246 Danforth St., BP# 2017-01447 plan review comments

DATE: 09-08-17	ISSUED TO: LP	CHRISTOPHER CAMPBELL ARCHITECTURE	246 DANFORTH ST PORTLAND ME	SCALE:
				PROJ. NO.
		PO BOX 7004 PORTLAND, MAINE 04112 CELL: 207-329-8344	FACADE IMPROVEMENT PROJECT BUILDING SECTION & ELEVATIONS	DRAWING NO. A-4

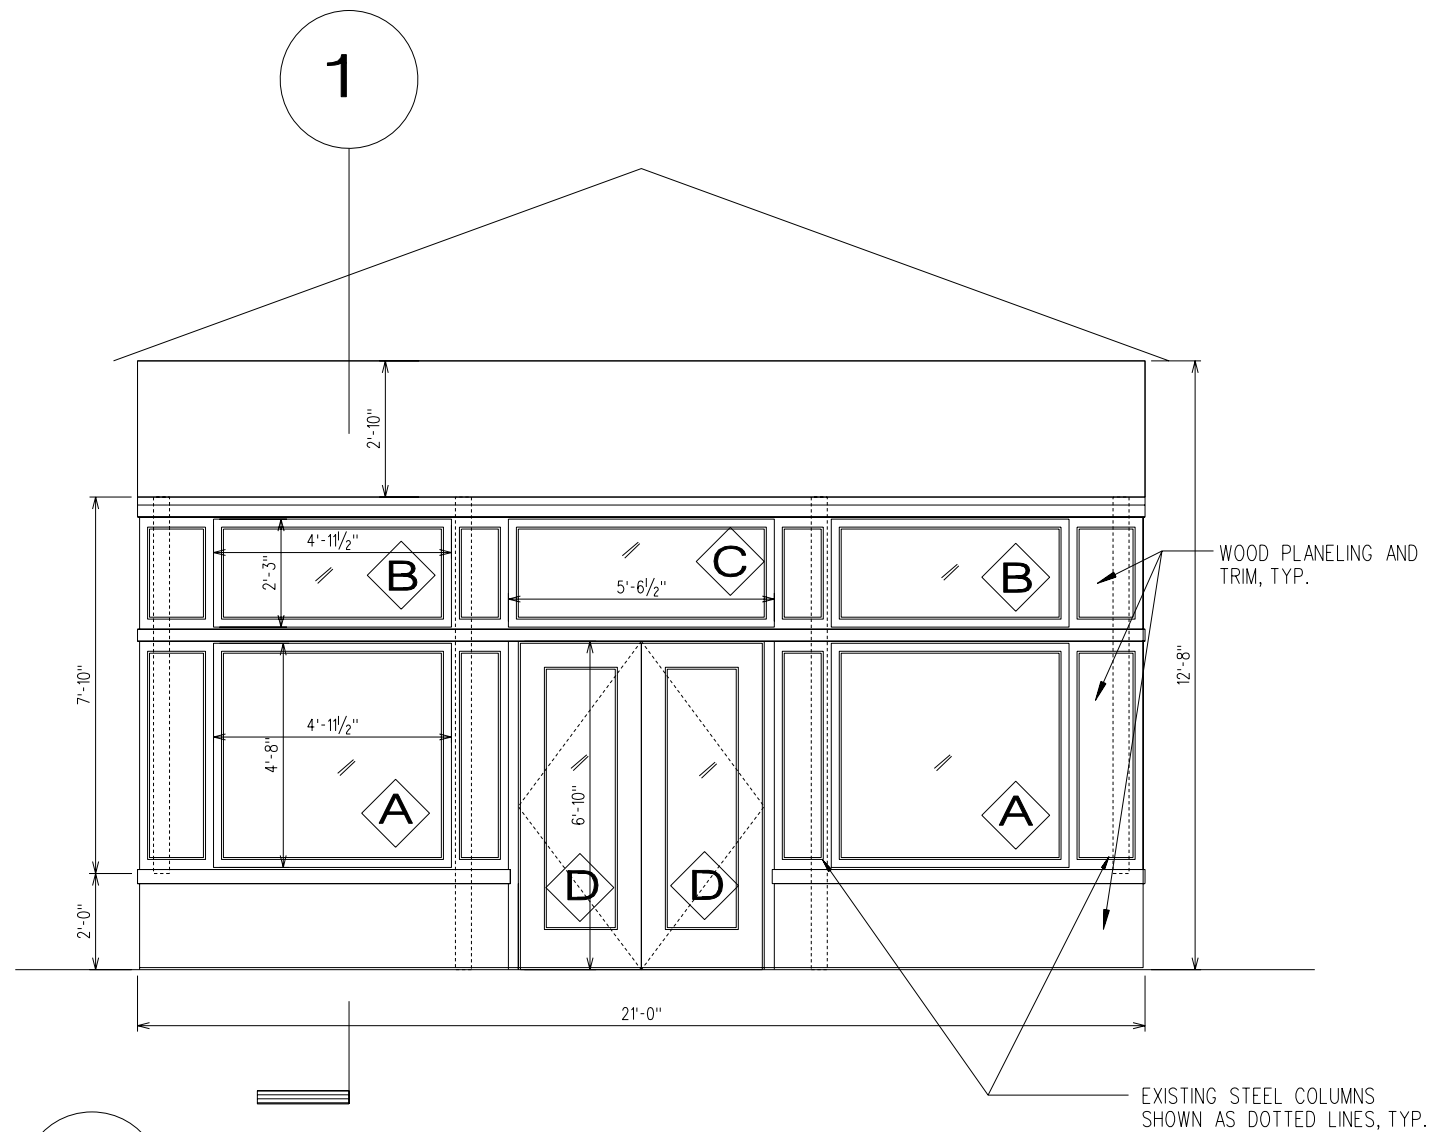
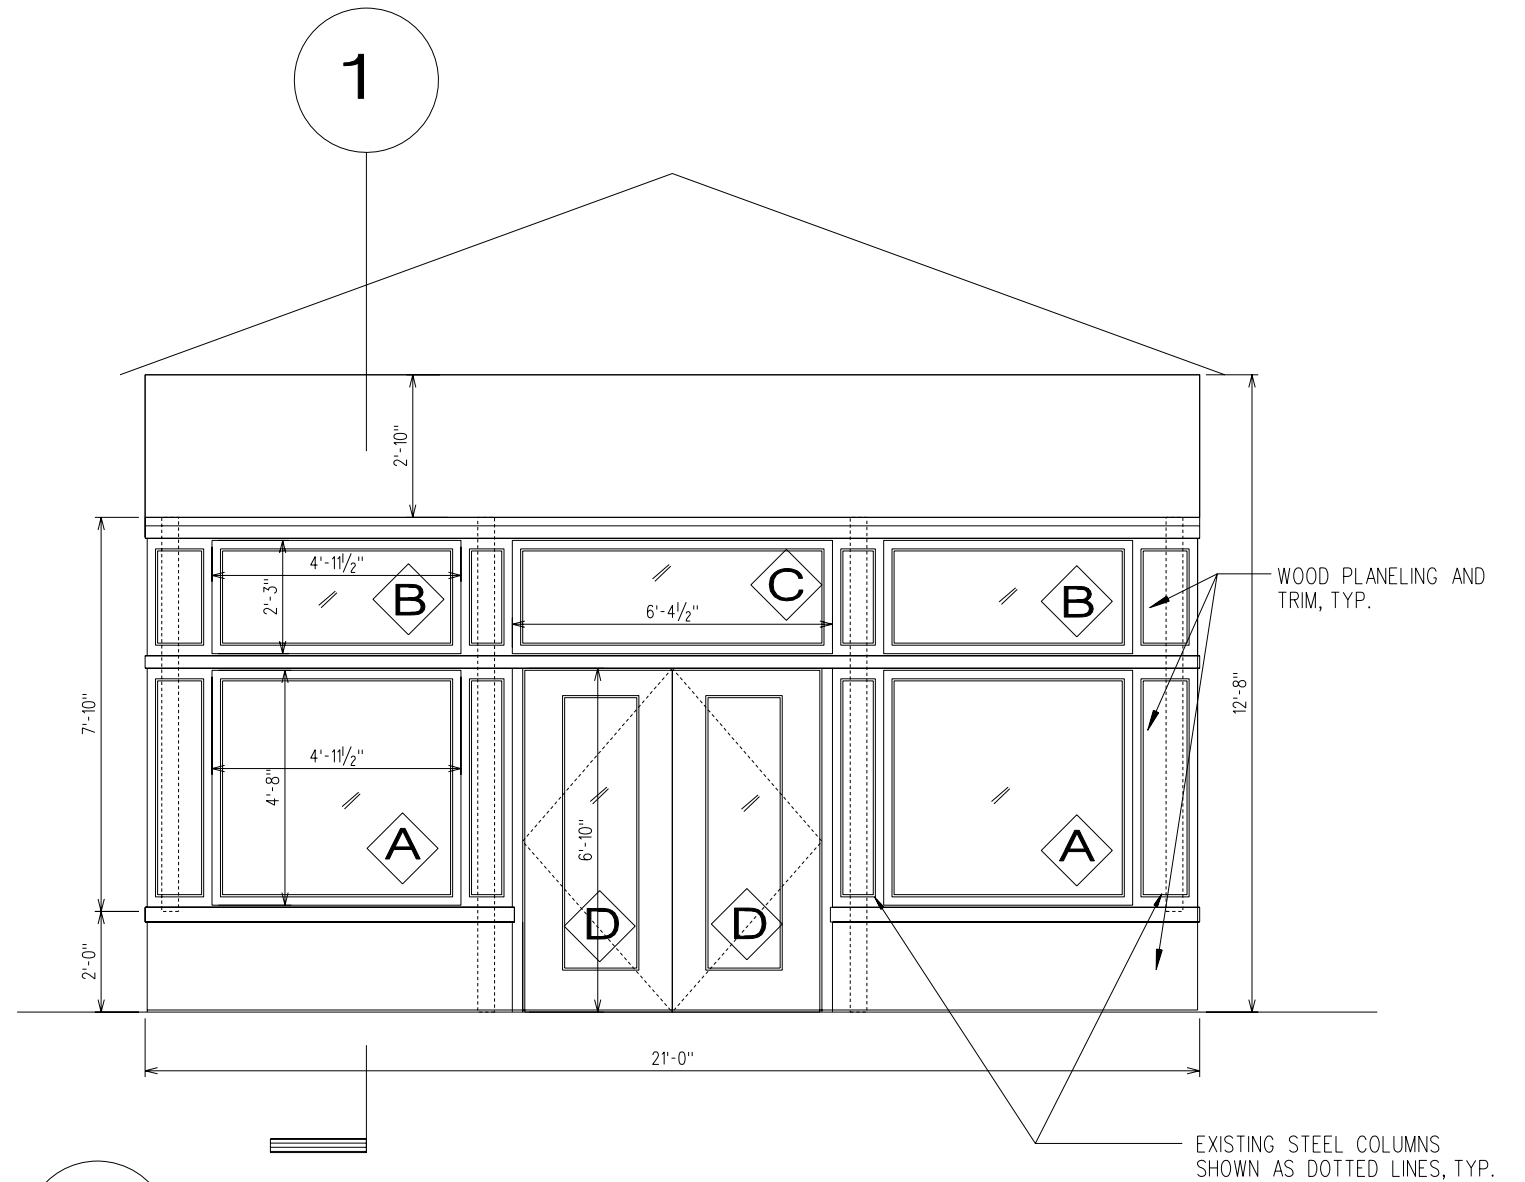
I have completed the review of this project for building code compliance and have made comments on the attached file(s) for you to address. In addition, can you please include a description with details on how this is used as an "art studio"?

Please find attached the revised A-4 drawing specifically addressing your concerns regarding item D on the door schedule. The door leaves will be 34" wide by 81.5" high and will provide at minimum a 32" clear opening at 90 degrees, complying with IBC 1008.1 and ADA Sec. 404.2.3. In addition, door hardware will comply with ADA Sec. 404.2.7
